Re: Project No. HL-12303-DLJ/RWW
FID No. 943190
Good Hope Hospital
Airborne Infection Isolation Room Renovation
Erwin (Harnett County)

The engineering portions of the construction documents dated March 24, 2021 (received April 16, 2021 – fee paid May 7, 2021) for the referenced project above have been reviewed for conformance with licensure rules for Hospitals (10A NCAC Chapter 13 Subchapter B). The drawings are not approved until we receive satisfactory written responses to architectural comments in DHSR letter dated June 2, 2021 and to the following engineering comments:

1 FLOOR PLAN
 1/8" = 1'-0"

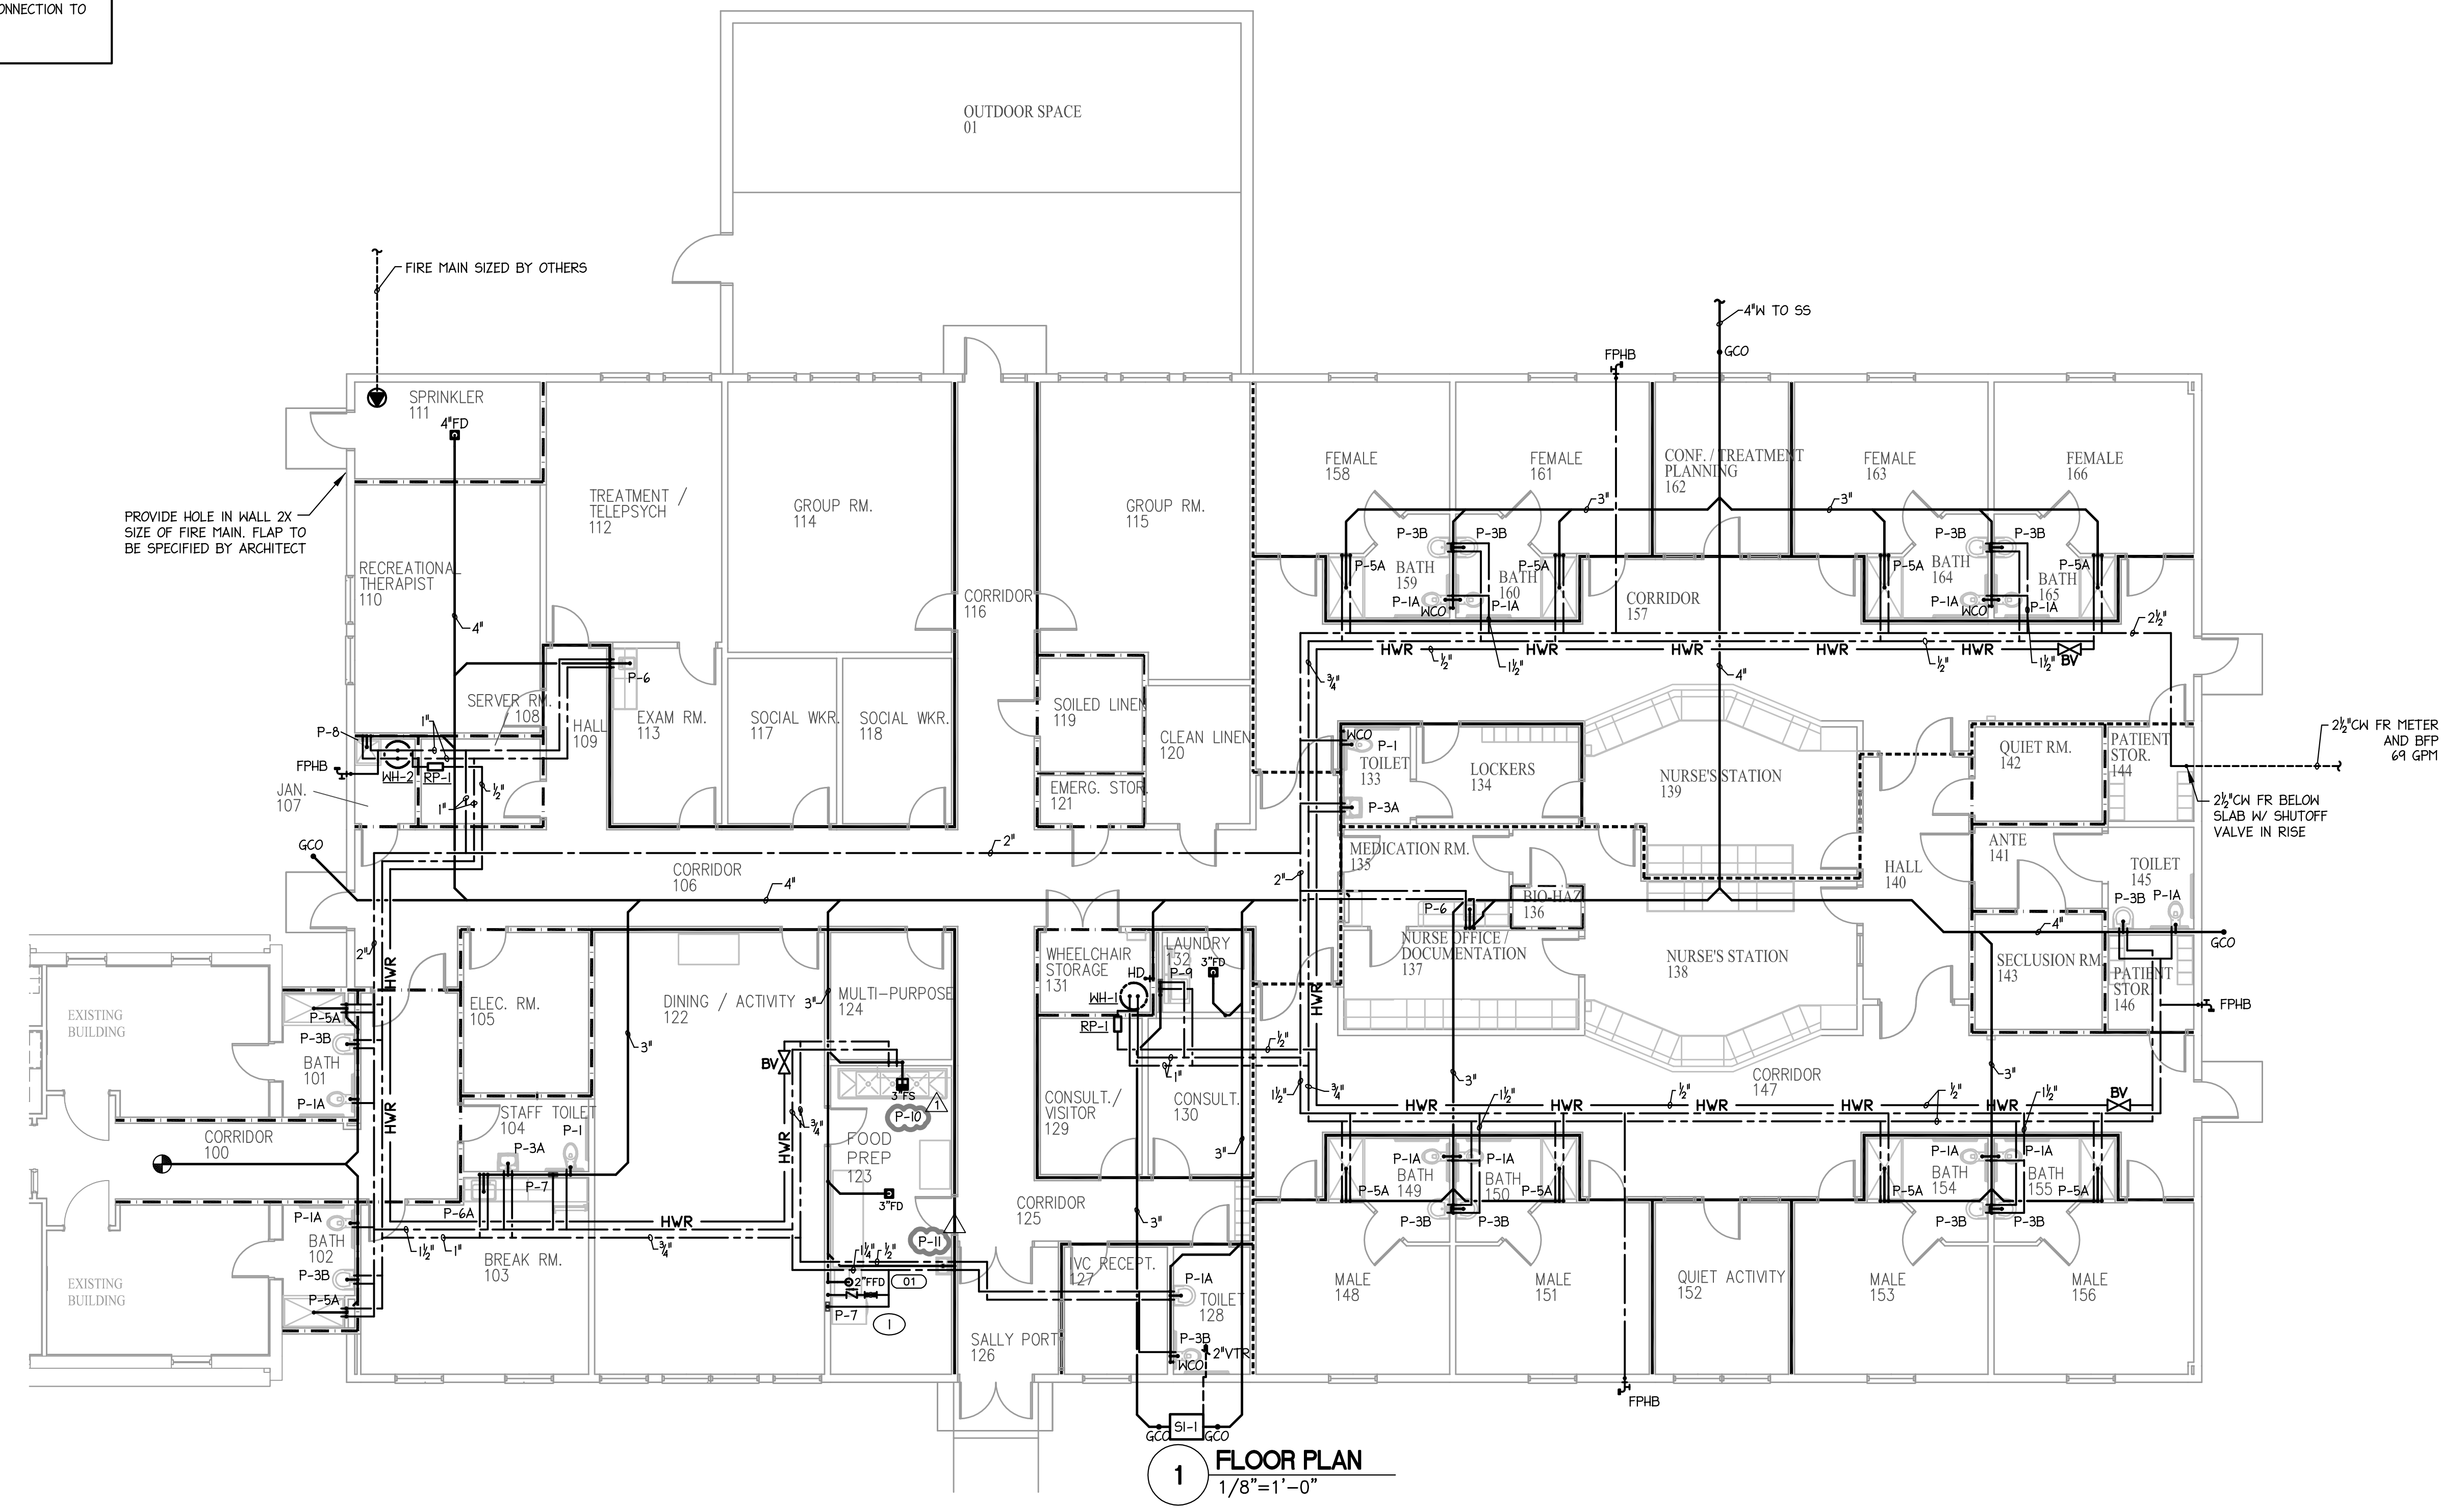
6. Reference Sheet P1.1: The type, quantity, and location of medical gas outlets provided to these renovated rooms is not indicated on these drawings. As the bed location is changed within the scope of this project, provide updated medical gas drawings that comply with 2018 FGI, Table 2.1-3 and 2012 NFPA 99, Chapter 5.

1 FLOOR PLAN
 1/8"=1'-0"

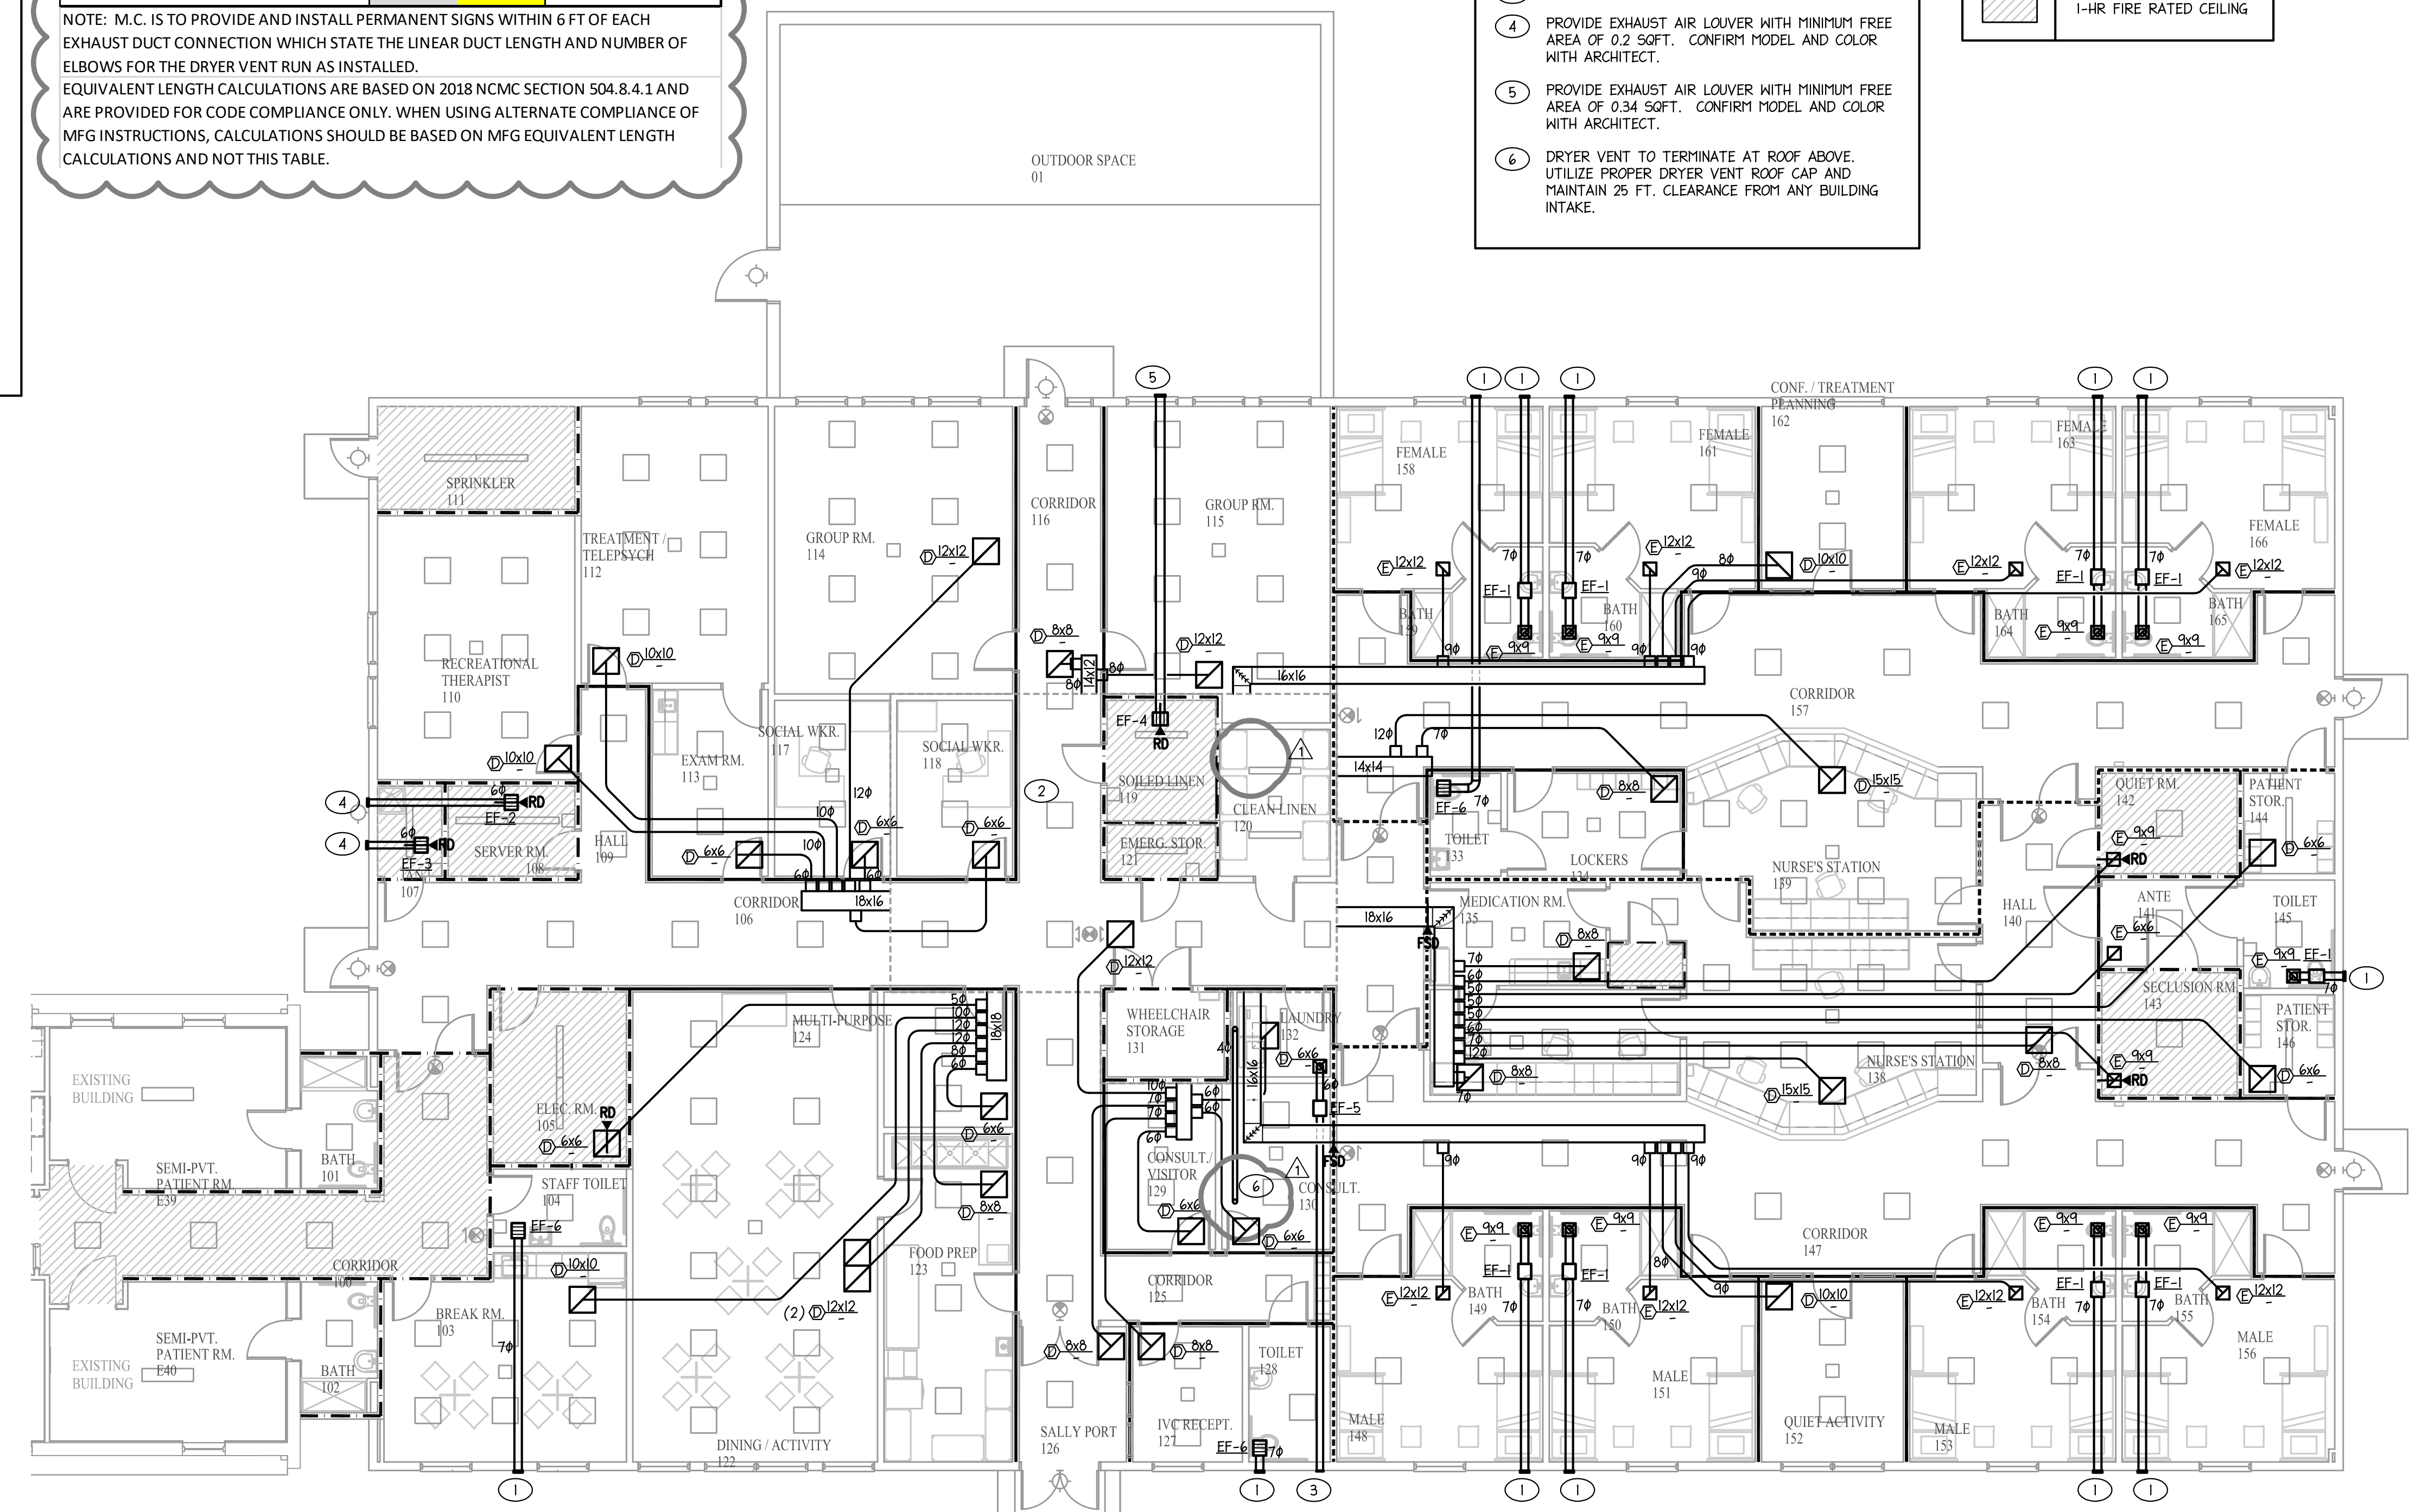
1. Reference Sheet M1.1: What is the location for the emergency stop switch for the new AHU-1? Please indicate on the drawings. [2018 NCMC 405.2]
2. Reference Sheet M1.1: A note on Detail 2 indicates a discharge cap on the AII exhaust outlet. Please note, the outlet must discharge in a vertical direction with no rain cap or other device to impede vertical movement and must be at least 10 feet above roof level. [2017 ASHRAE 170 6.3.2.2.a.] Revise the drawings as necessary.

3. Reference Sheet M1.1: Detail 2 on this sheet indicates 10 feet clearance between AII exhaust and any outside air intake. The required separation is minimum 25 feet from all outdoor air intakes, openable windows, and areas normally accessible to the public. [2017 ASHRAE 170 6.3.2.2.c.] Please revise the drawings as necessary.

4. Reference Sheet M1.1: Please confirm the anteroom pressure relationships with adjacent spaces (comply with 2017 ASHRAE 170 7.2.1.g. Revise the drawings as necessary.

5. Reference Sheet M1.1: The drawings indicate air change requirements per the 2018 NCMC. Verify that all AII room requirements of 2018 FGI/2017 ASHRAE 170, including Tables 6.4, 6.7.2, and 7.1, are also met. Please revise the drawings as necessary.
